CITY OF PORTLAND BUILDING PERMIT

PERMIT ID: 2013-00436

has permission to **Renovation & addition from former army barracks to hotelminium with 22 units-
Change of USE.**

Project Name: The Inn at Diamond Cove
Address: Diamond Cove, Building 46
Applicant: The Inn at Diamond Cove
Planner: Richard Knowland

Ø4 TYPICAL STEEL RAIL DETAIL  
SCALE: 1/2"=1'-0"

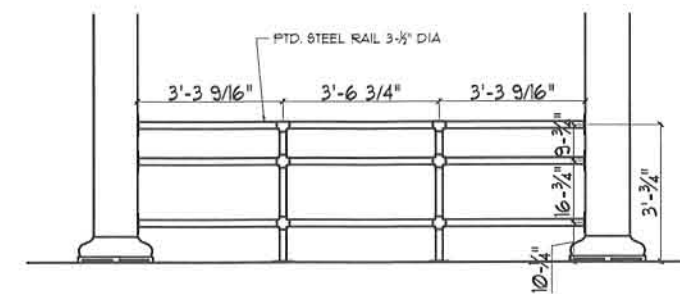
- 4) THE EXTERIOR BALCONIES, DECK, AND STAIR PIPE RAIL DESIGN IS NOT APPROVED WITH THE ISSUANCE OF THIS PERMIT. ALTERNATIVE DESIGNS SHALL BE SUBMITTED FOR APPROVAL FOR CODE COMPLIANT OPENING LIMITATIONS AND HEIGHT PRIOR TO THE FABRICATION OF SAID RAILS.

- 1) Additional permits are required for kitchen hood and suppression systems.
- 2) A firefighter Building Marking Sign is required.
- 3) **The proposed gaurds have not been approved. The applicant is to submit revised plans for compliance with NFPA 101:7.2.2.4.5.**
